# CITY OF ALBUQUERQUE

**Re: Mirehaven Improvements Grading Plan  
Engineer's Stamp Date 4-15-14 (H09D017D)**

## COA

**Meeting Objective:** Discuss Mirehaven Arroyo Improvements Report and Plans

TYPICAL GRADE CONTROL STRUCTURE

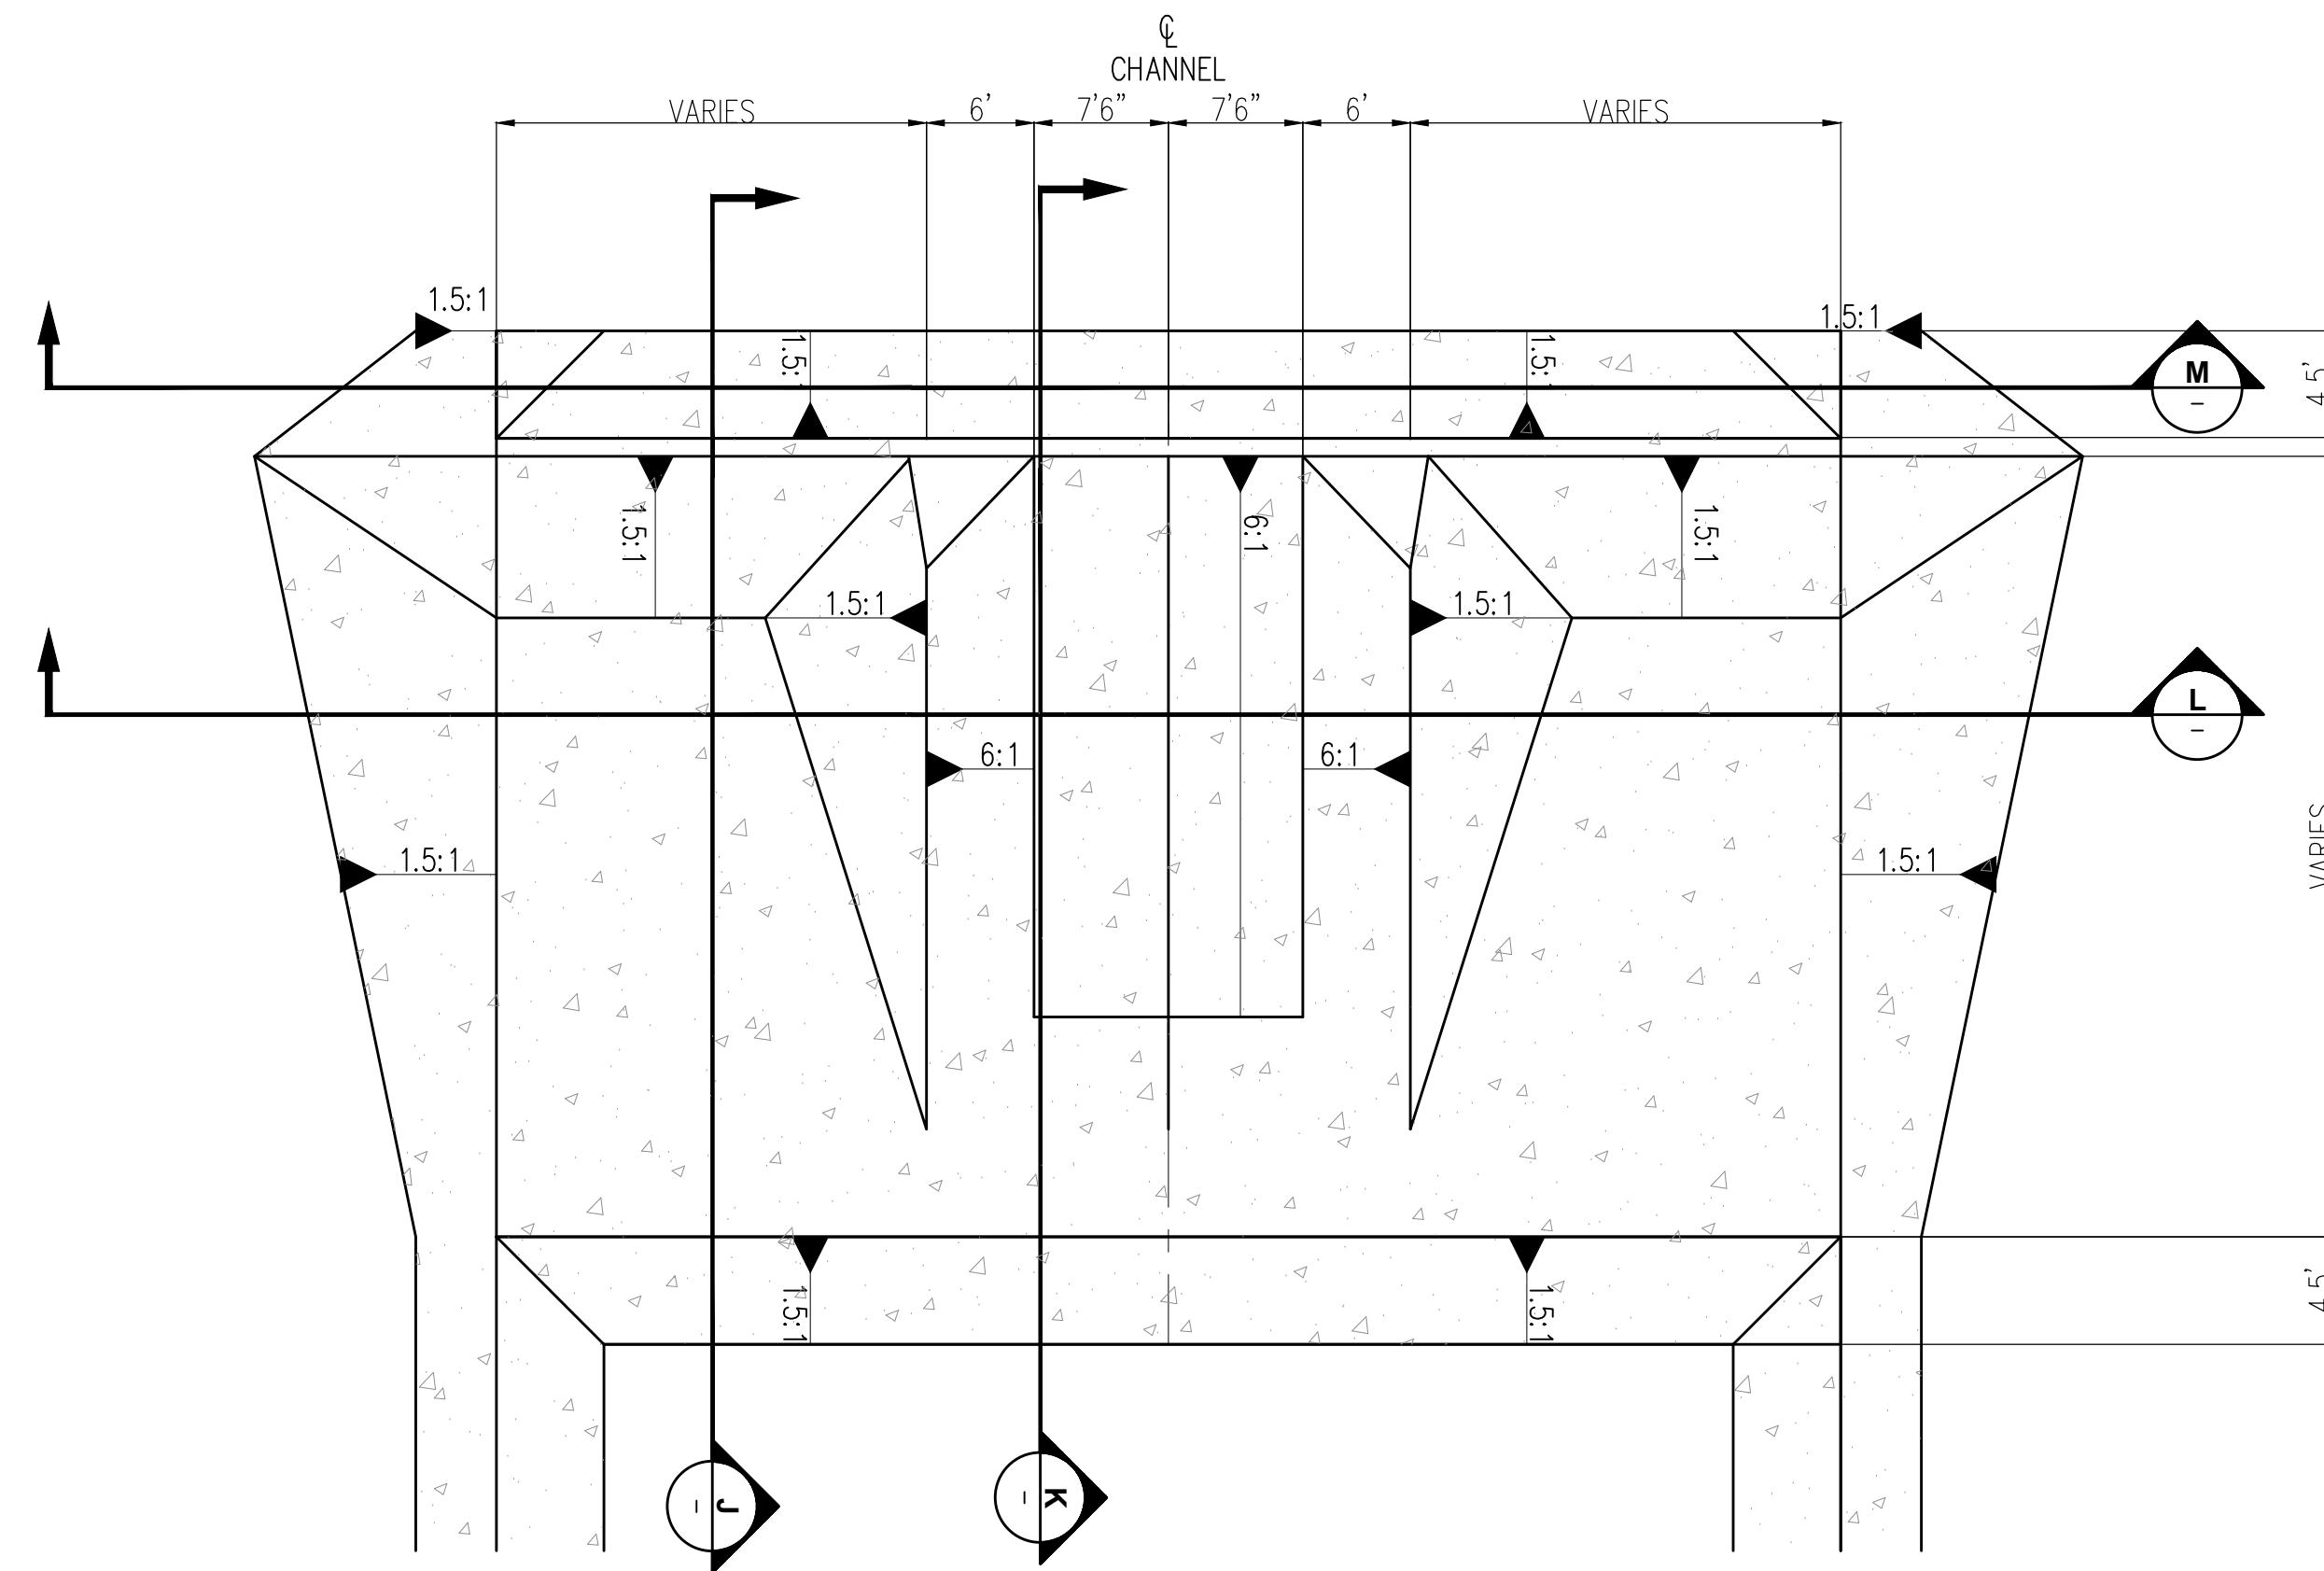
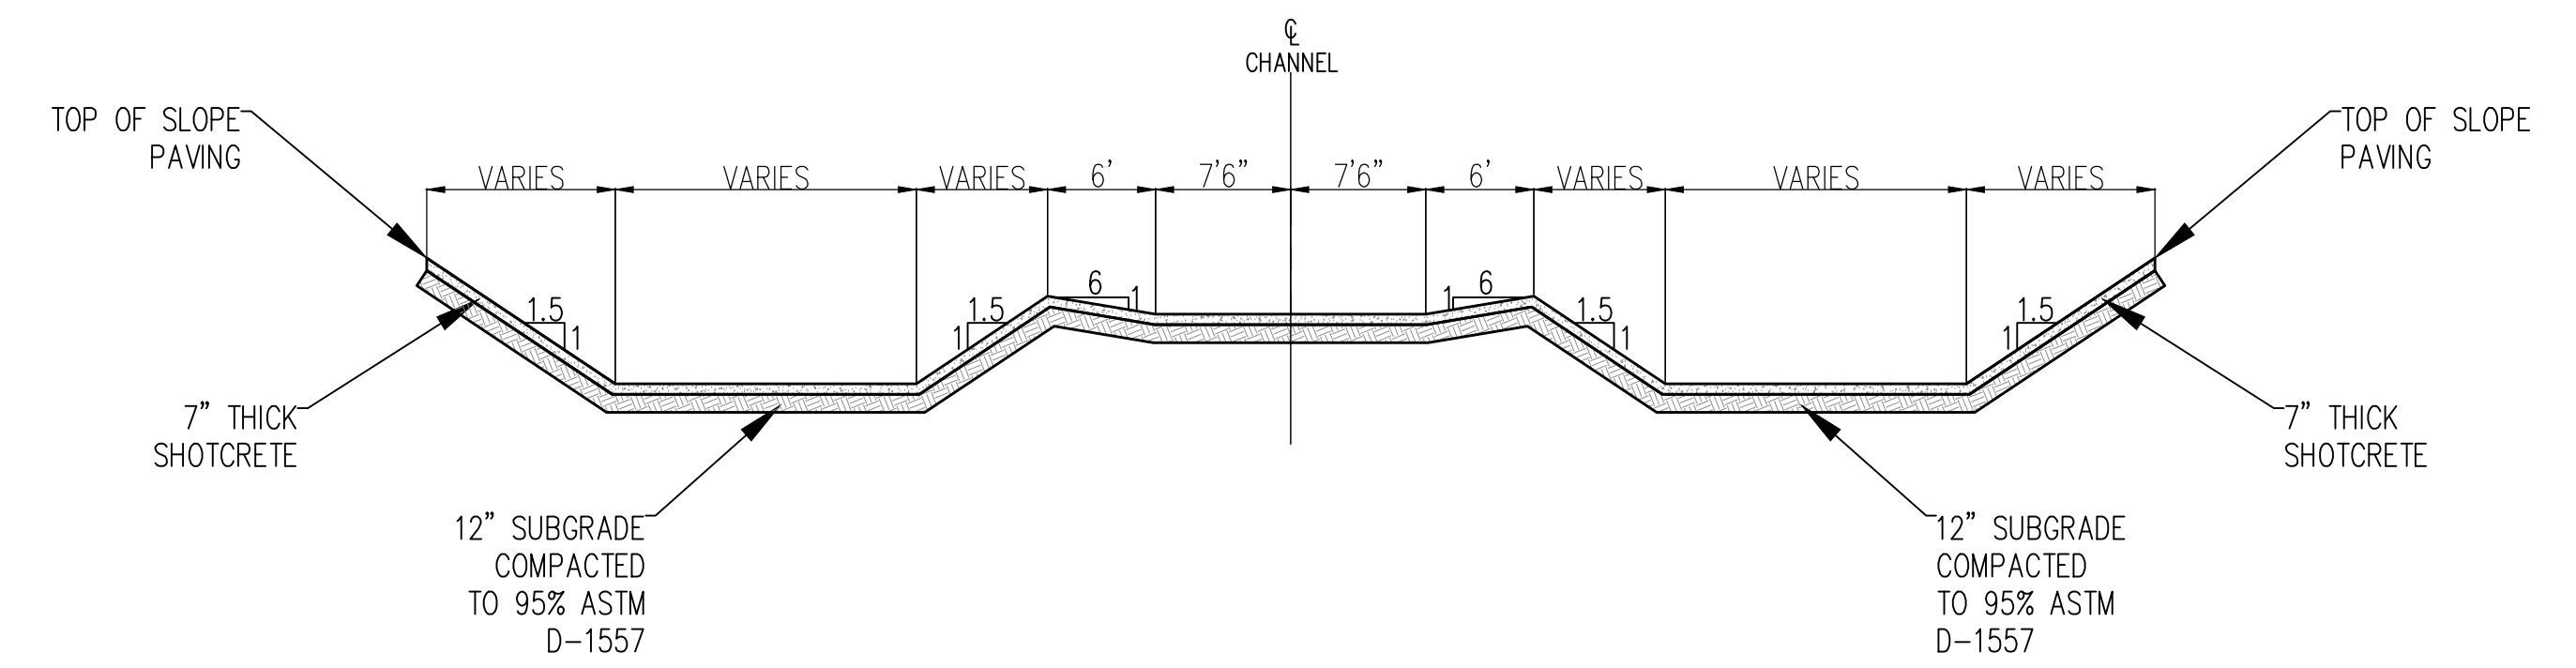
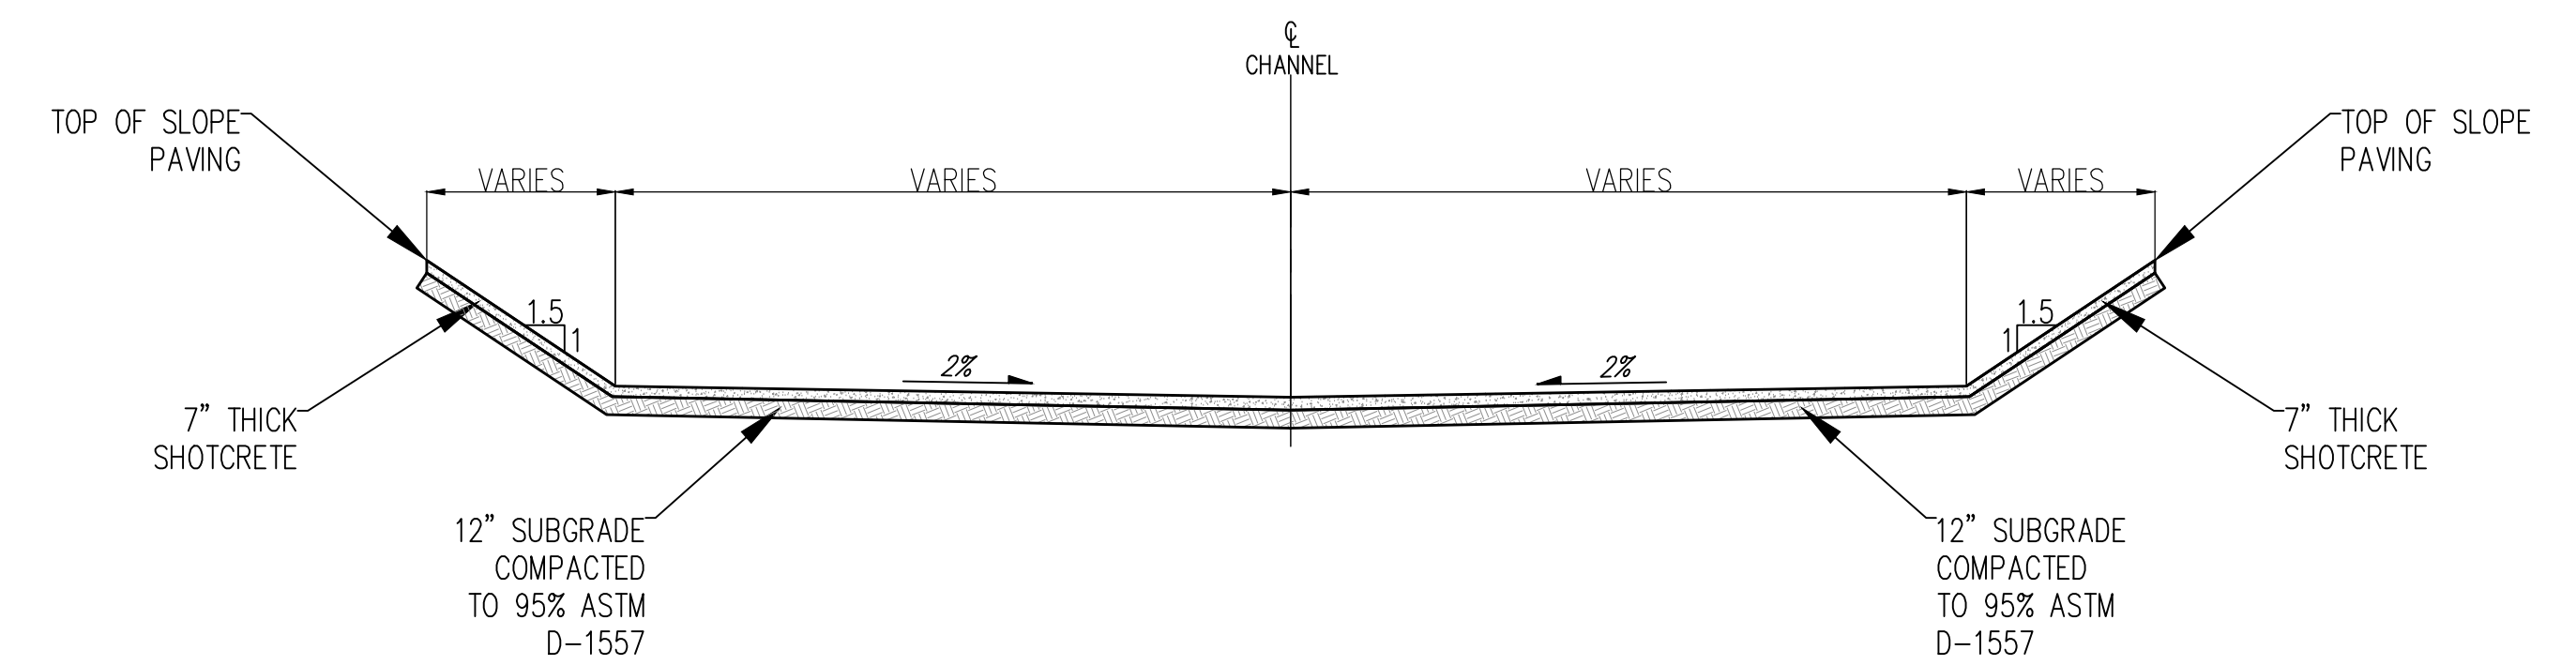
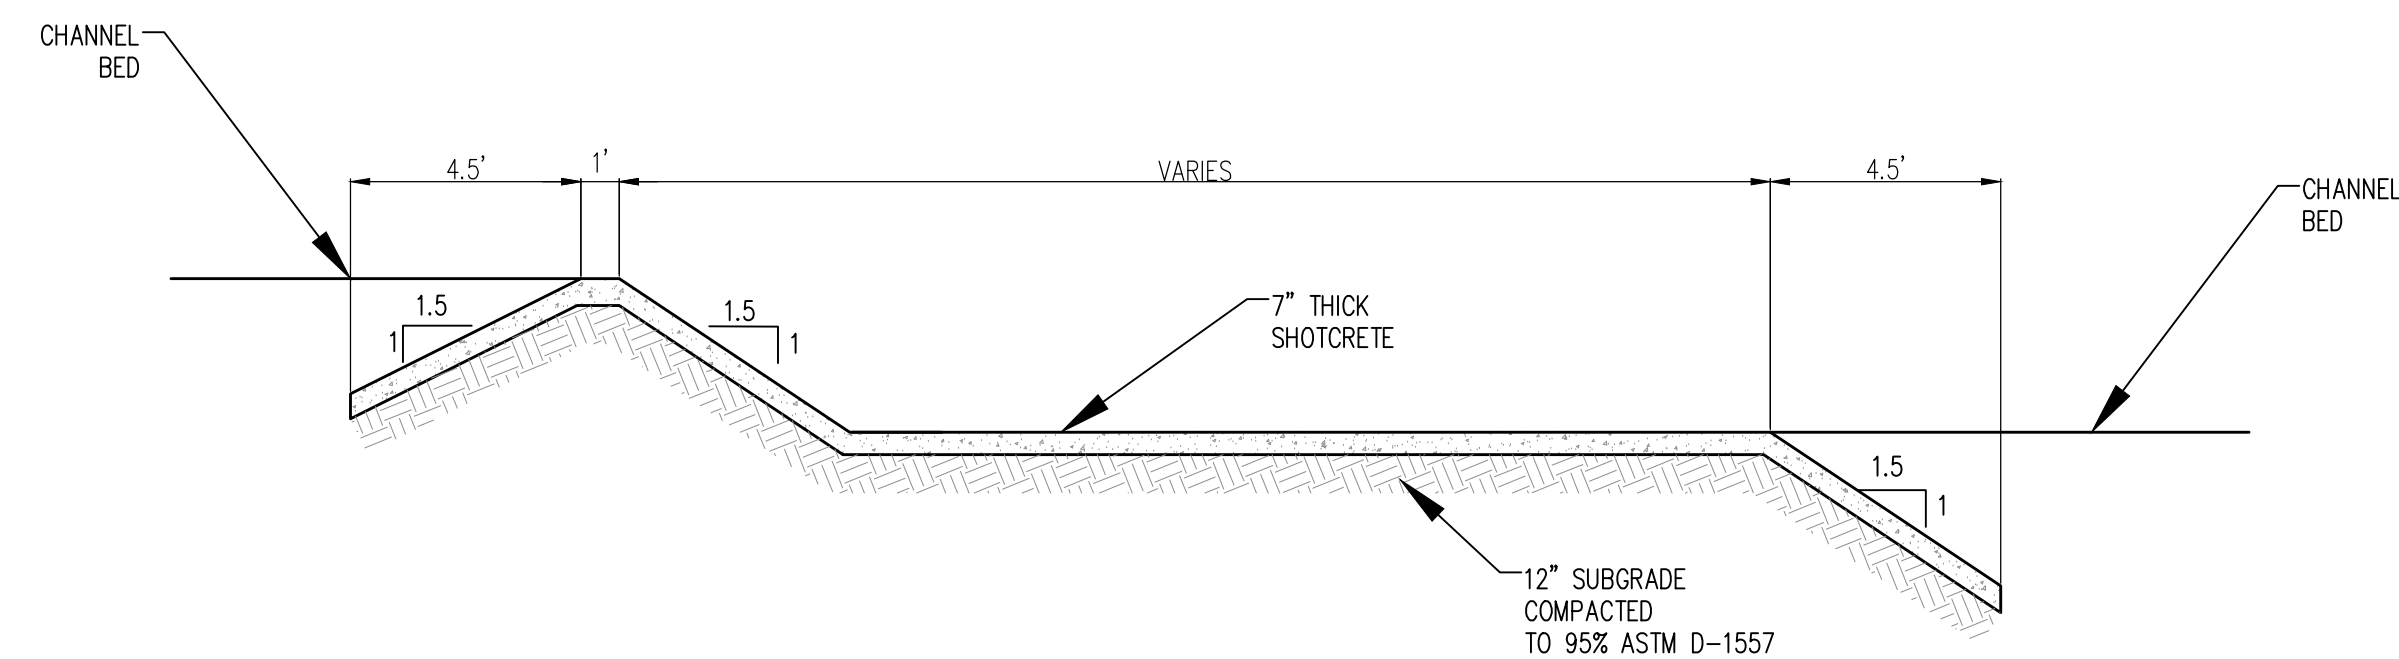
There was a general discussion on drop structures and the details of the final design. The final design reflects the drop heights and locations based on the easement boundary, the grade needed in the arroyo and the adjacent subdivision grades outside the arroyo. A profile with the proposed grades, the previous design grades, and the existing grades was reviewed.
